**Northern
Development
Assessment**

**RE: SSD-75493483 – INTEGRATED SENIORS LIVING DEVELOPMENT – OBJECTION TO STATE
SIGNIFICANT DEVELOPMENT APPLICATION.**

PPTY: 2–32 JUNCTION STREET, FOREST LODGE NSW 2037 (SUBJECT SITE)

1 WEST ELEVATION
SCALE 1 : 250

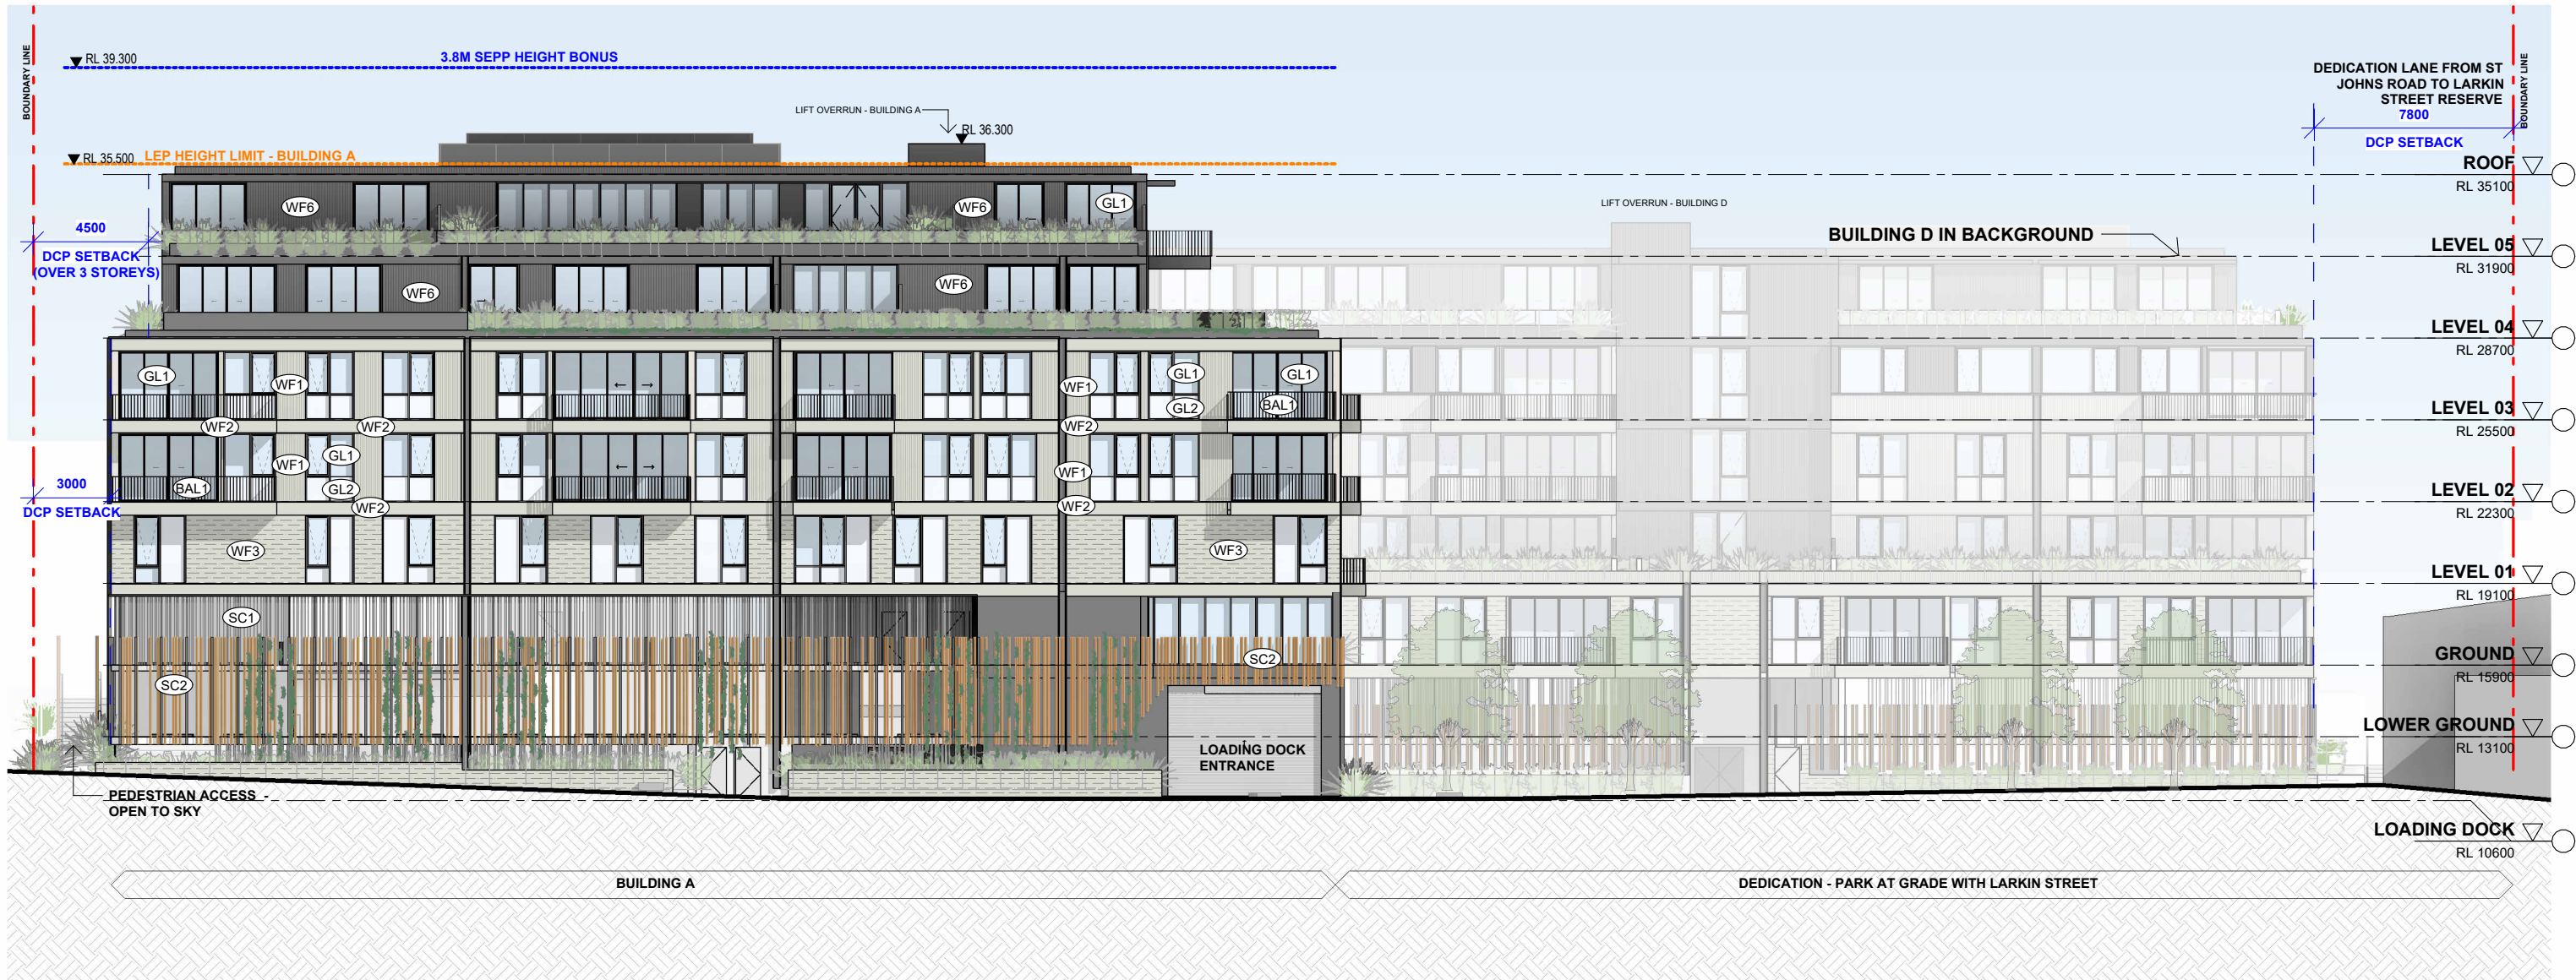
Within this overall exceedance, Level 5 of Building A represents the most visible and identifiable portion of wholly non-compliant floor area. This level contributes approximately 246 m² of additional GFA to the development and sits 3.2 metres higher than Buildings B, C and D. In addition to this measurable floor area, Level 5 accommodates substantial built elements that are excluded from the formal GFA calculation for FSR purposes but that materially contribute to the building's perceived scale. These include the lift shafts and over-run, rooftop AC plant, hot-water plant, communal corridors and staircases. Although not counted as GFA, these structures add significant bulk to the upper portion of Building A, amplifying its dominance when viewed from the adjoining property at 1–3 Larkin Street.

The result is a development with upper massing and a fifth storey that forms the visual apex of the development and introduces a discordant height and massing relationship along the western boundary. The additional level disrupts the consistent roofline of Buildings B, C and D and generates a continuous upper-level wall that appears monolithic from nearby residences. From 1–3 Larkin Street, this uppermost level replaces sky views with solid built form and accentuates the overall sense of enclosure and overshadowing.

The proposed development, however, introduces a new five-storey building (Building A) along the western boundary of the site, which includes two full levels of floor space above what would be achievable under a compliant 1.25:1 FSR. Building A is also the only structure on the site to include a fifth storey, which sits 3.2 metres higher than the remainder of the development and contains an additional 246 m² of wholly non-compliant floor area. Together with Level 4 (1,034 m² across all buildings), these levels represent the bulk of the 3,377 m² FSR exceedance across the site and are the primary cause of the loss of skyline views from 1–3 Larkin Street.

The fifth storey and associated rooftop plant, lift overruns and service structures extend well above the established roofline of the retained Federation warehouse (Building D) and entirely occupy the existing view corridor to the Sydney CBD skyline. The result is a wall-like built form that removes the sense of sky, depth and relief that currently defines the eastern outlook from the adjoining building. The VIA photomontages (Figures 38a–38c) confirm that Sydney Tower—the most recognisable feature of the existing view—would be completely lost from almost all vantage points within 1–3 Larkin Street.

In numerical terms, the 3,378 m² of additional floor area across the development equates to more than half again the total built form that the planning controls anticipate. Level 5 of Building A alone represents the most visible and intrusive expression of this overdevelopment. Its deletion, together with reduction of upper-level floorplates across other buildings, would be required to bring the proposal back within a compliant envelope and achieve a more balanced scale and character consistent with the locality.

GFA CALCULATION	
LOADING DOCK	43 m²
GROUND	1674 m²
LEVEL 01	2136 m²
LEVEL 02	2083 m²
LEVEL 03	2022 m²
LEVEL 04	1160 m²
LEVEL 05	289 m²
TOTAL GFA	9407 m²

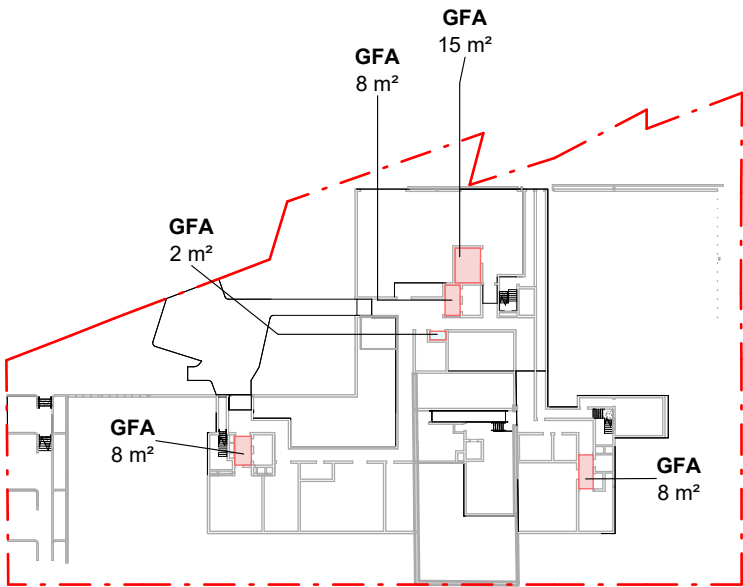
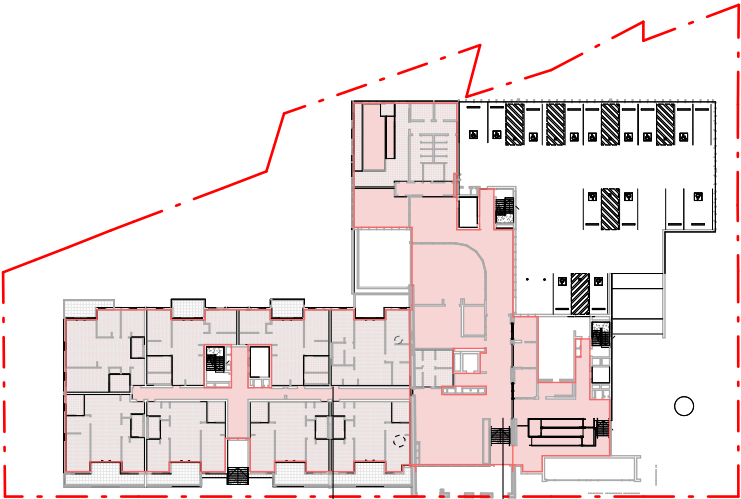
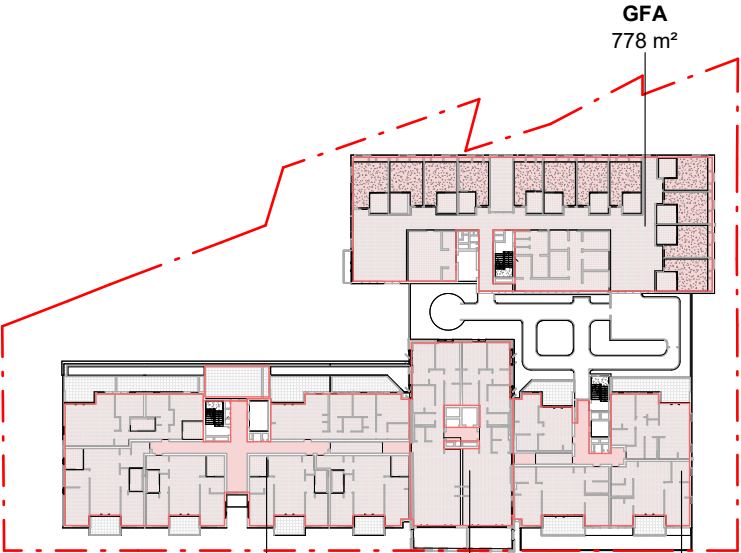
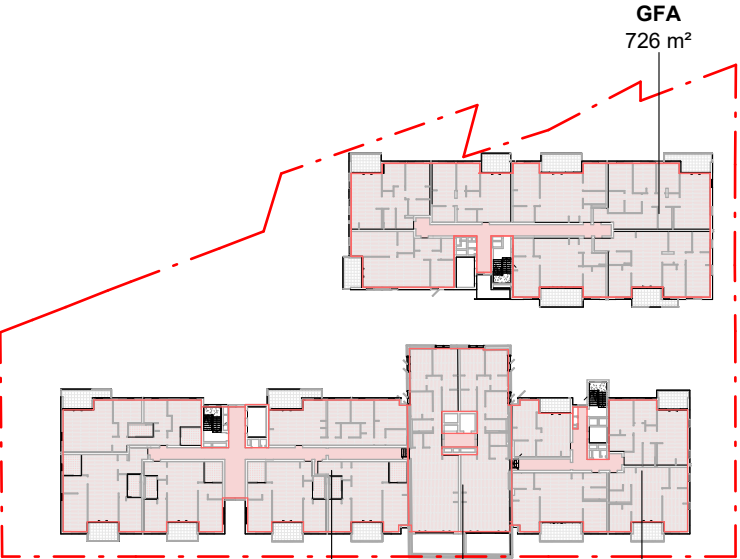
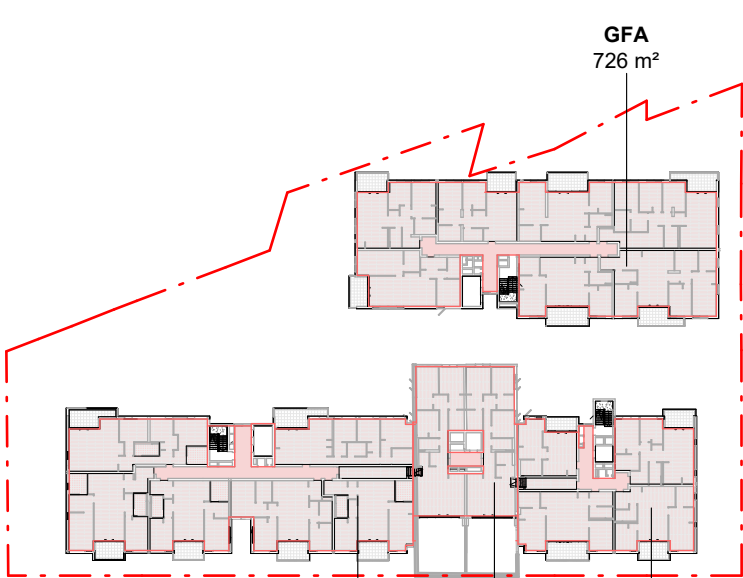
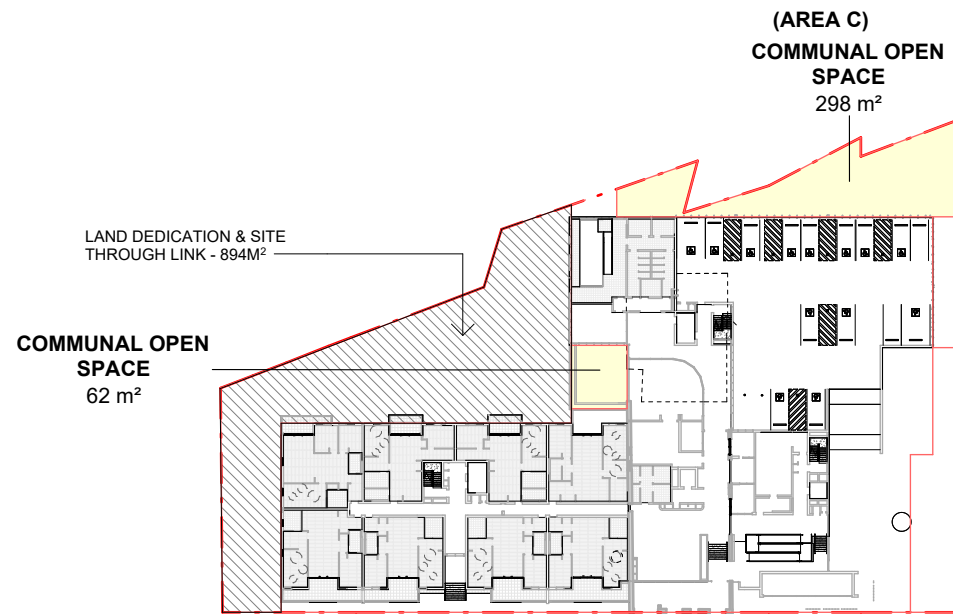
Based on the site area of 4,824 m², the maximum permitted gross floor area (GFA) under the Housing SEPP is 6,030 m². The proposal provides a total GFA of 9,408 m², resulting in a non-compliant excess of approximately 3,378 m² of additional floor area beyond what is permitted. These figures relate only to the areas formally included within the GFA calculation and therefore do not reflect the full extent of the built form. They exclude substantial building components such as communal hallways, lift shafts, stairwells, mechanical plant rooms and other service areas which, while not counted toward GFA for the purpose of FSR compliance, nonetheless contribute significantly to the overall bulk, height and visual dominance of the development. When these non-GFA elements are considered, the perceived scale of the building—particularly at the upper levels—is considerably greater than that implied by the numerical exceedance alone.

This non-compliance is further highlighted by the calculation of Level 4, which spans Buildings A, B, C and D and contributes an additional 1,034 m² to the total gross floor area. Even if both Levels 5 and 4 were deleted in their entirety, the proposal would still exceed the permissible 6,030 m² GFA by approximately 2,098 m². This demonstrates that the development substantially exceeds the allowable density across multiple levels, not only within the uppermost storey of Building A. The extent of the exceedance confirms that achieving compliance would require more than the removal of the non-compliant fifth level—it would necessitate significant reductions in floorplate size, increased setbacks and a comprehensive redesign of the building envelopes to deliver a development consistent with the intended 1.25:1 FSR and surrounding urban context.

This amount of excess development cannot be accommodated within the approved building envelopes without substantial modification. Rectifying the breach would require the removal of entire upper levels, including Level 5 of Building A, or major reductions in floorplate dimensions through increased side, rear and front setbacks.
